**Consultation Response from KC,
Lead Local Flood Authority**
2021/93399 Land Adjacent to, 569 , New Hey Road, Mount, Huddersfield, HD3 3XN
Outline application for demolition of agricultural and storage buildings and erection of residential development (& dwellings)
**Date Responded:
27/09/2021**
**Responding Officer:
Martin Stephenson**
**Responding Ref:
0**
Drainage Comments

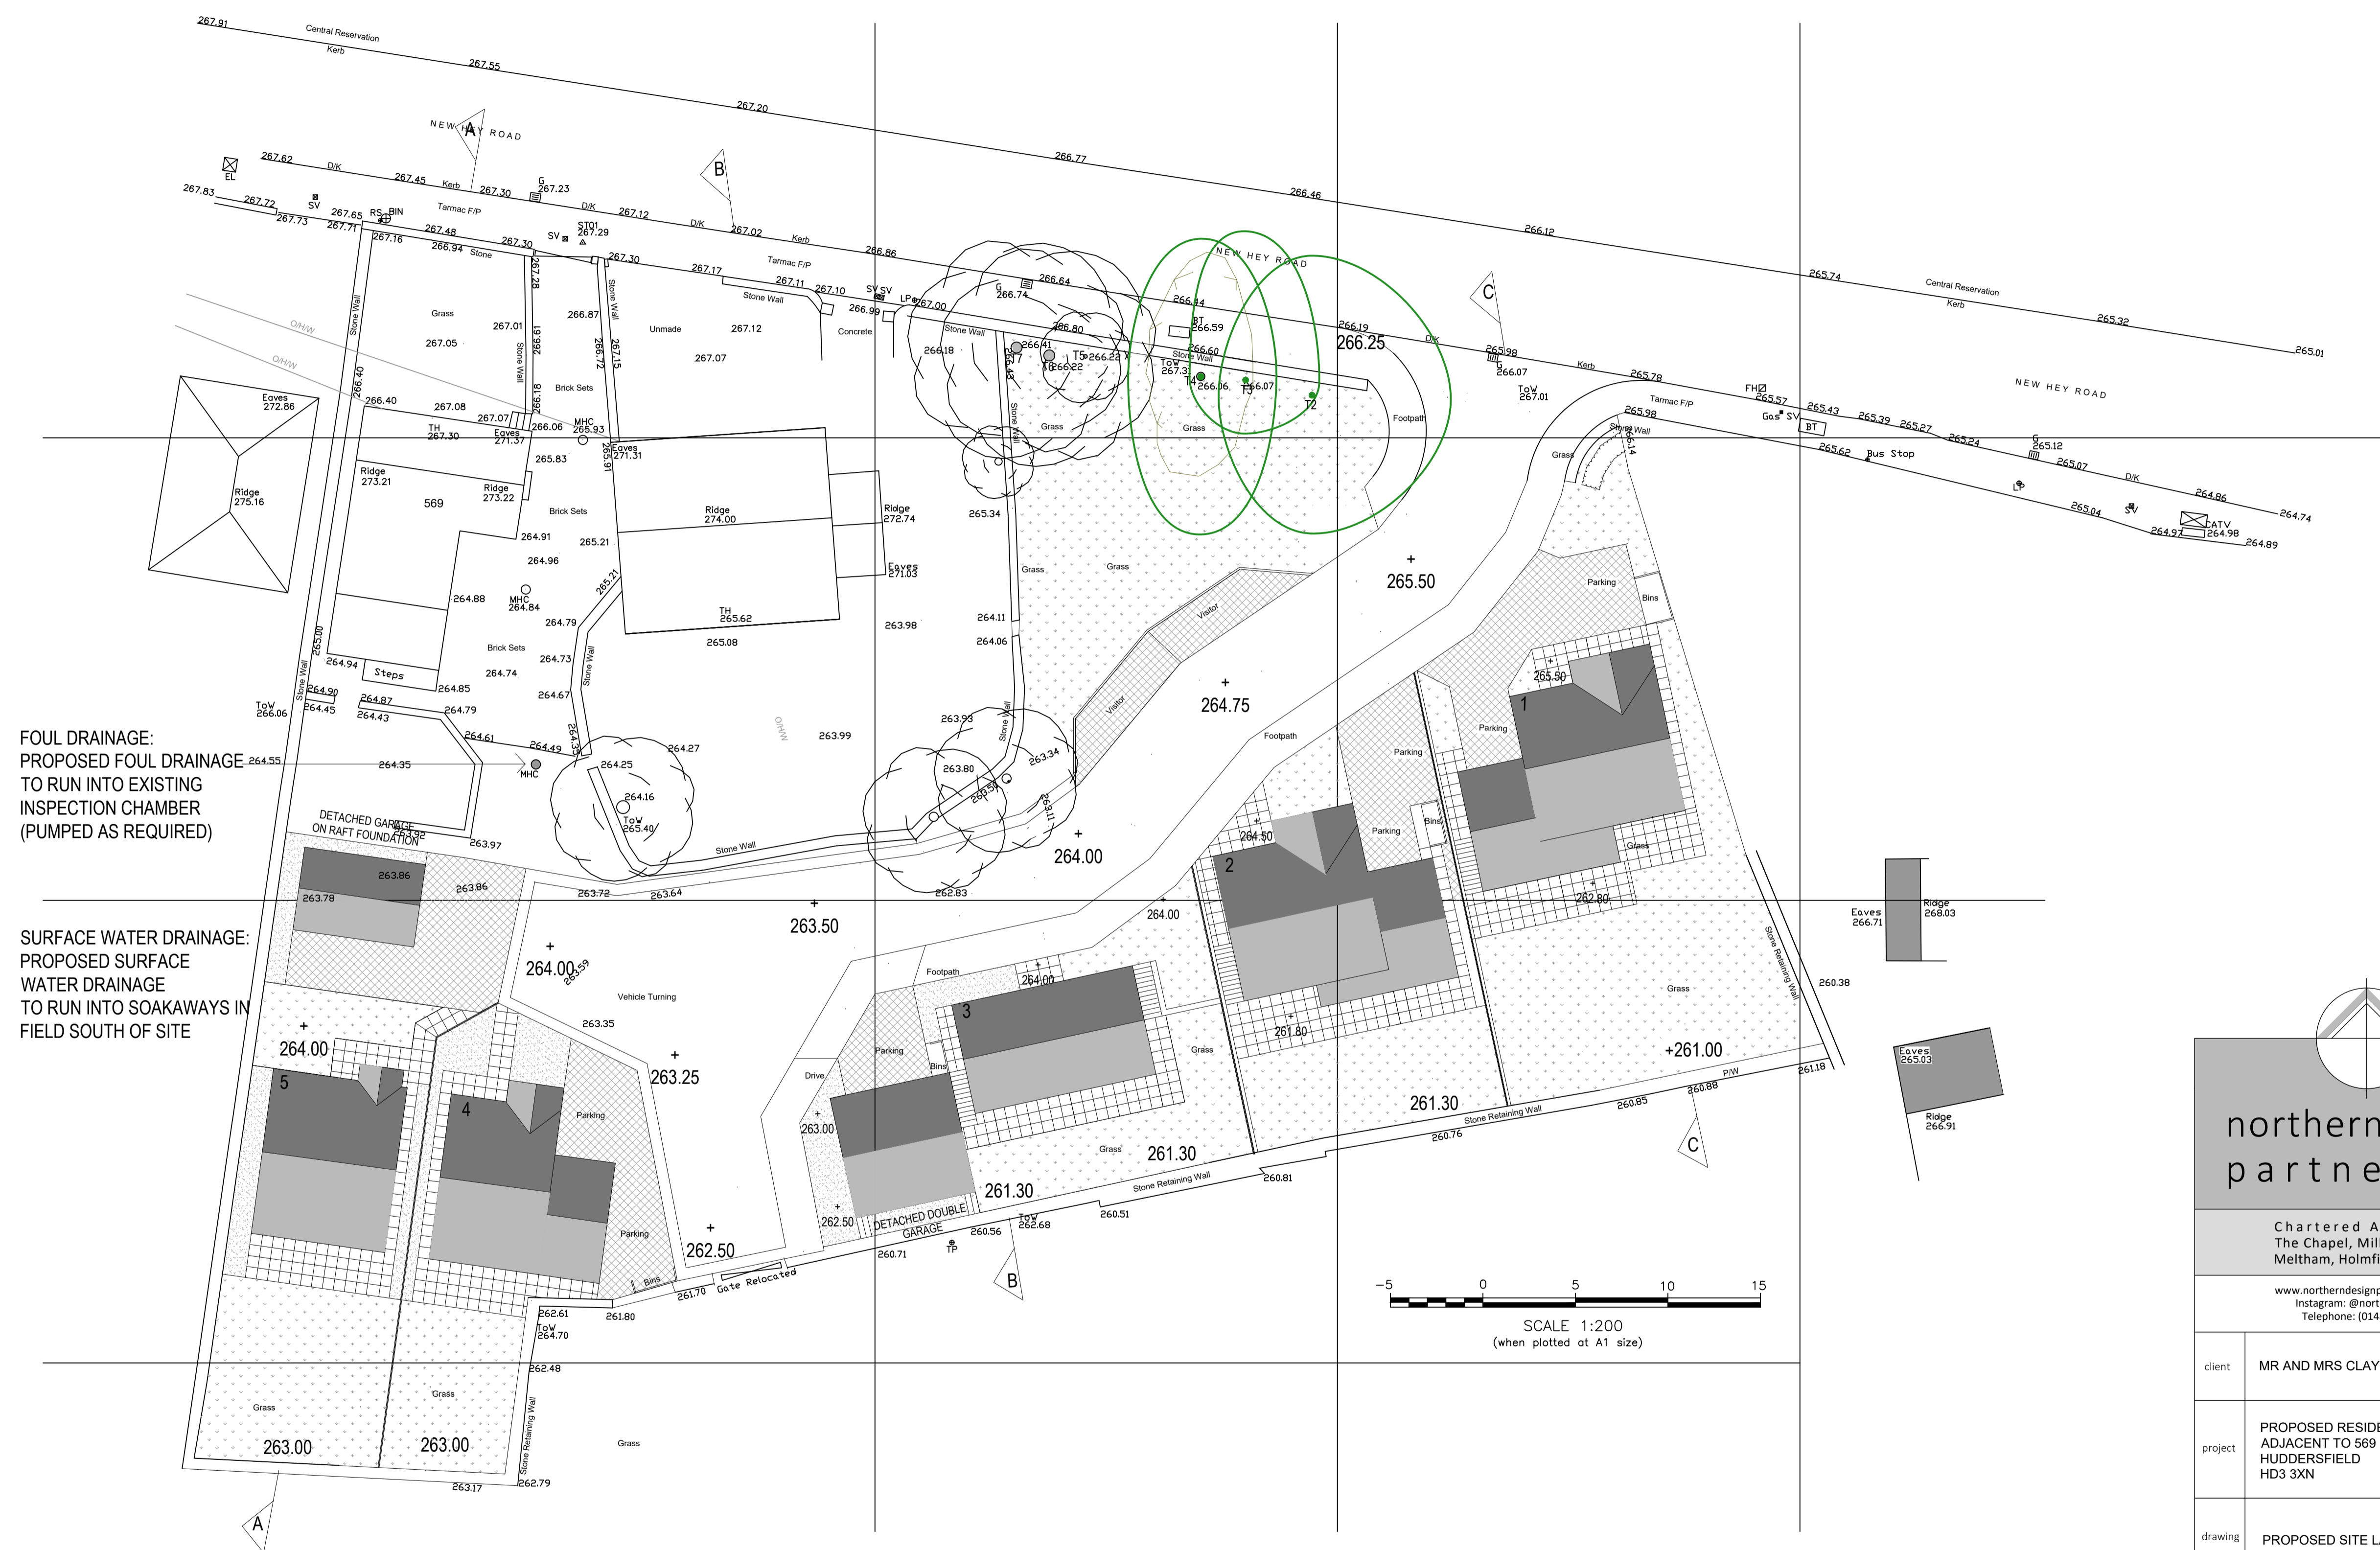
The LLFA notes from the application form that discharge of surface water is proposed to be to soakaways. Disposal to ground has the highest ranking in the hierarchy of disposal methods in CIRIA C753 SuDS Manual (Section 3.2.3) and therefore is encouraged where suitable by the LLFA.

Plans held by Kirklees Council indicate that the underlying soils may be suitable for soakaways, however the developer will need to provide evidence of the soakage rate at the location/s using the BRE Digest 365 percolation testing methodology with a minimum of 3 successful tests per trial pit location. The trial pits' depth should be at least at the base of any proposed soakaways.

It is not recommended that soakaways are sited on slopes steeper than 1 in 10 to reduce the risk of re-emergence of flows at the surface further down the slope.

Plans held by Kirklees Council indicate that there is a potential for surface flooding at the south-western boundary of the site with a predicted depth of up to 1.2 m for the 1 in 100 year rainfall event. The developer should ensure that external flooding into the site and internal flooding due to exceedance events within the site do not enter the curtilage of new or existing properties.
